RE: 189 St John/Maine Med

D Street Side Walk Impacts to [189 St. John Street](#) property

SITE LTG. CALCULATION PLAN - 1

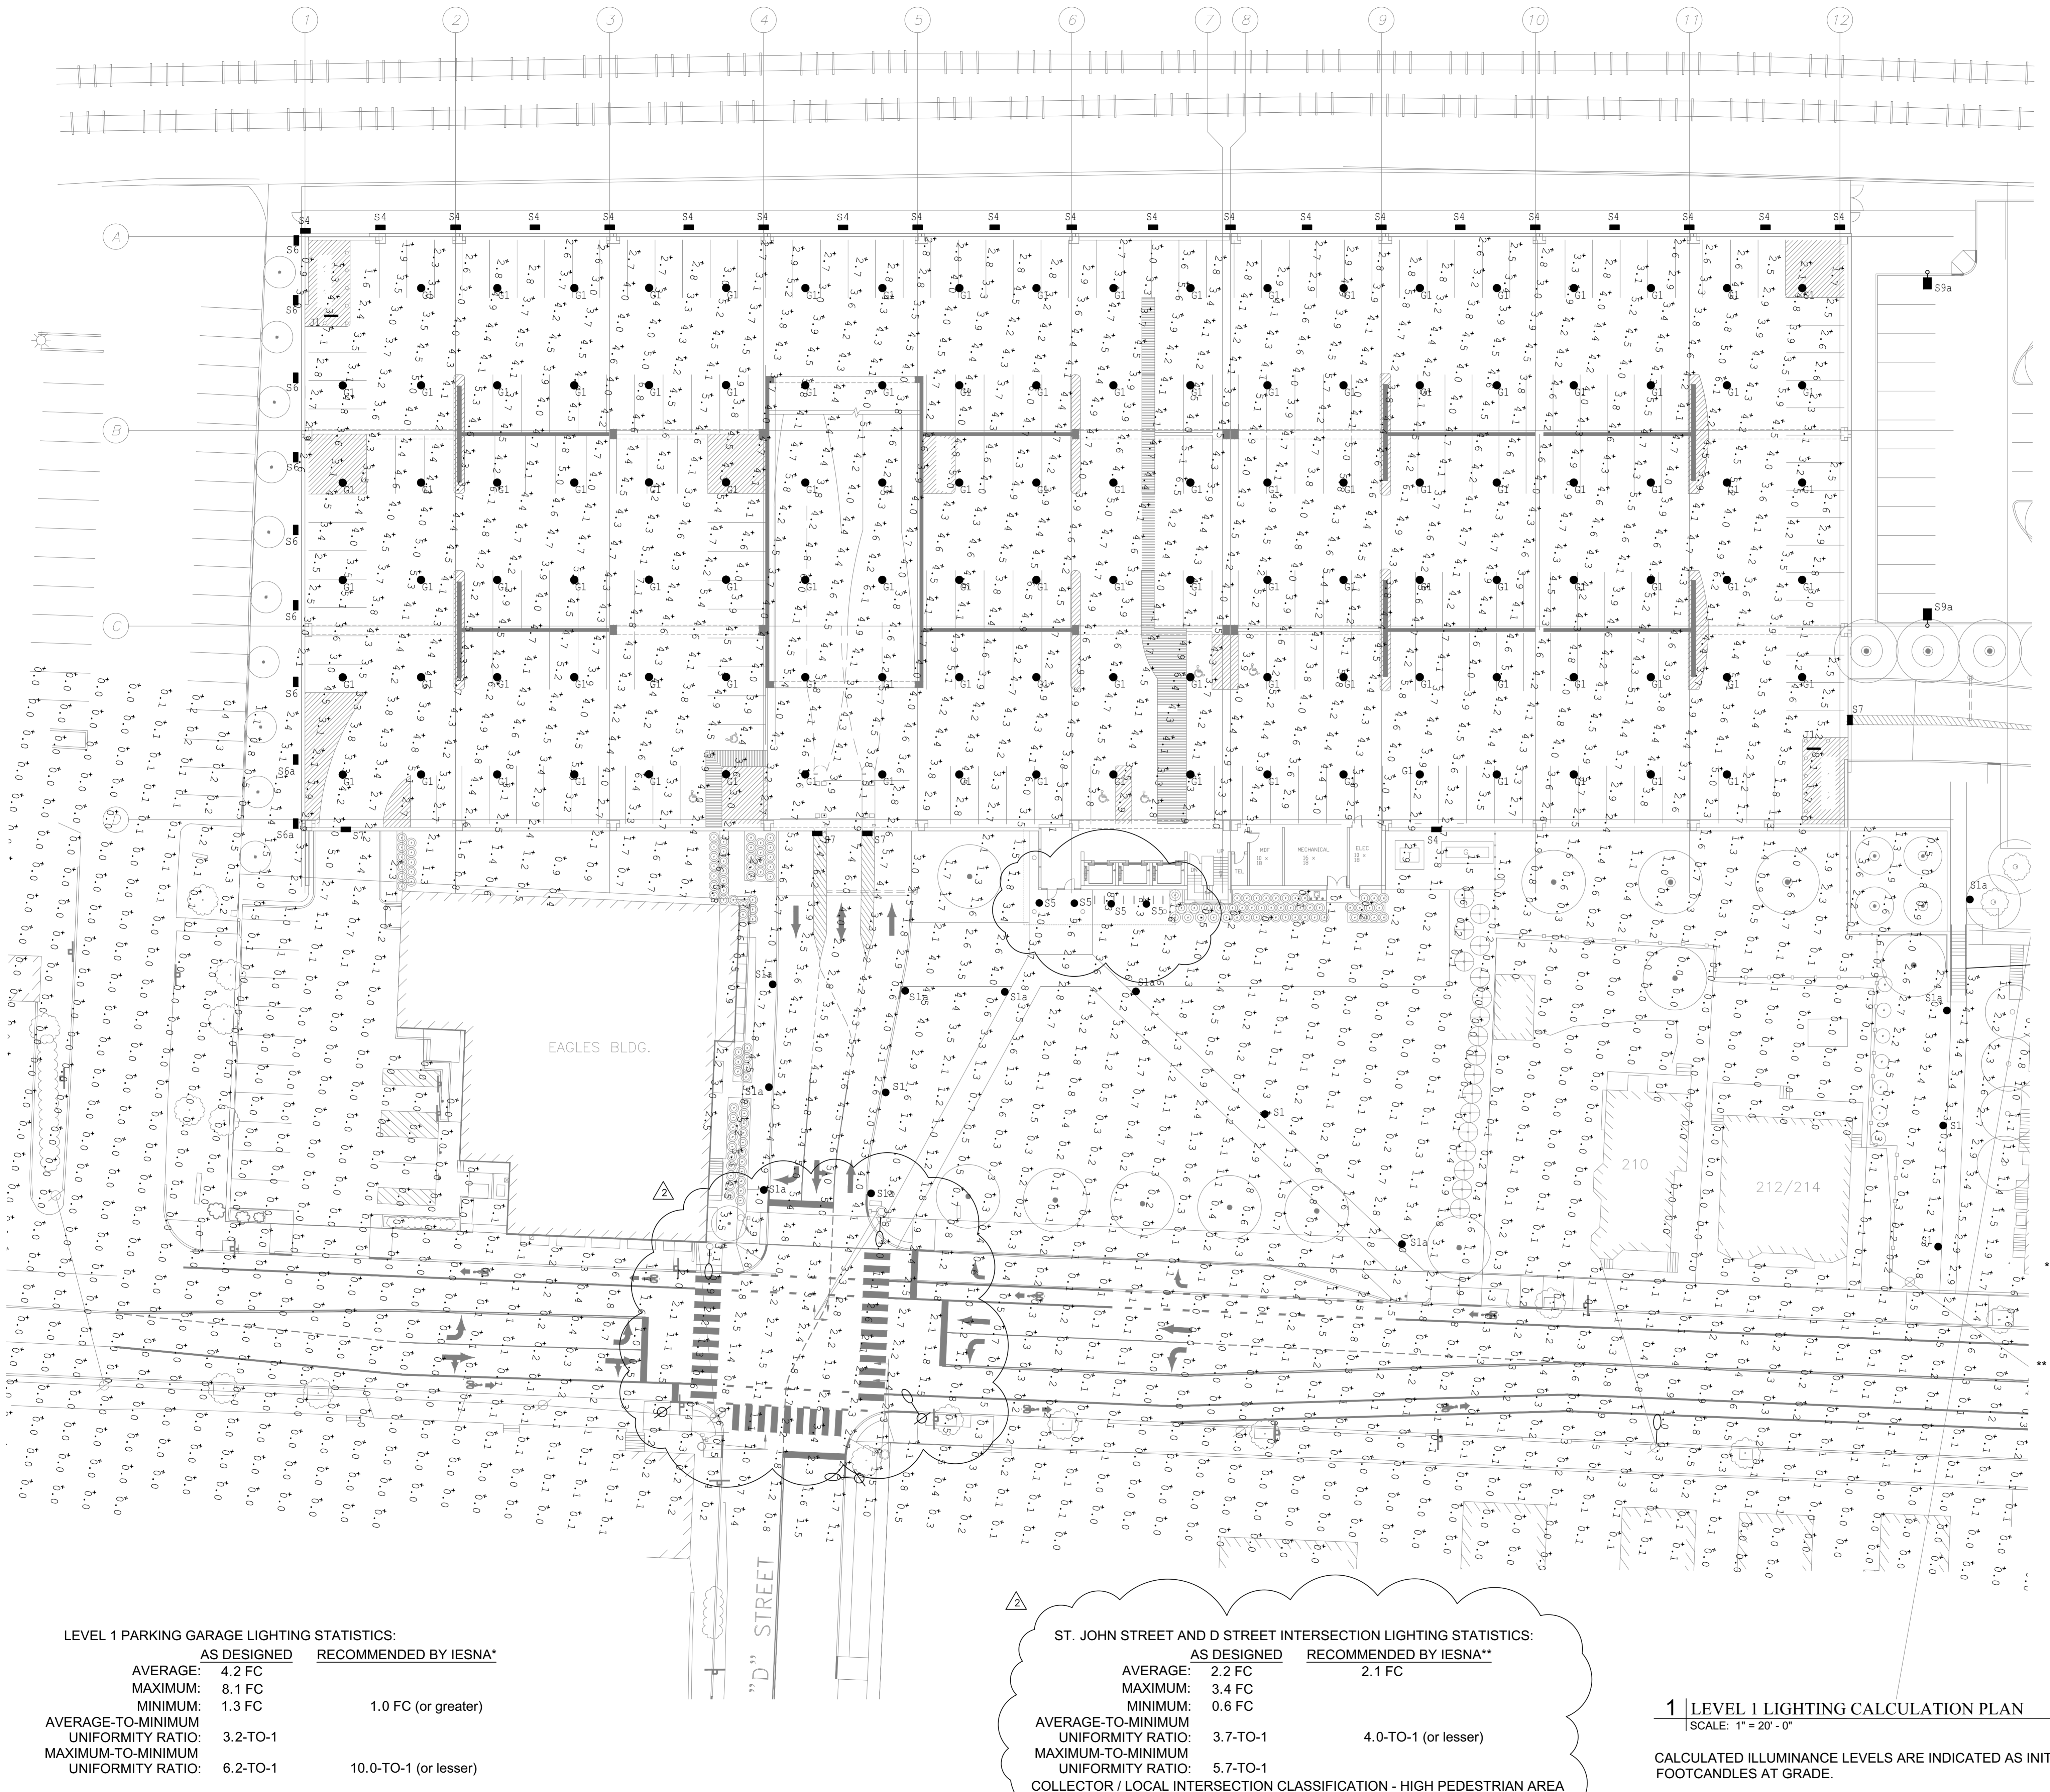
Concerning the plan, we're interested in what the lighting of the walkways will be and hope that it is more about low level, safety lighting rather than tall, old fashioned street lighting that will shine in our windows at night. The technologies exist that can direct light where needed and not add to overall light pollution in the city. We will also have to deal with the traffic lights of red, yellow, and green during the nights hours. This is a big change.
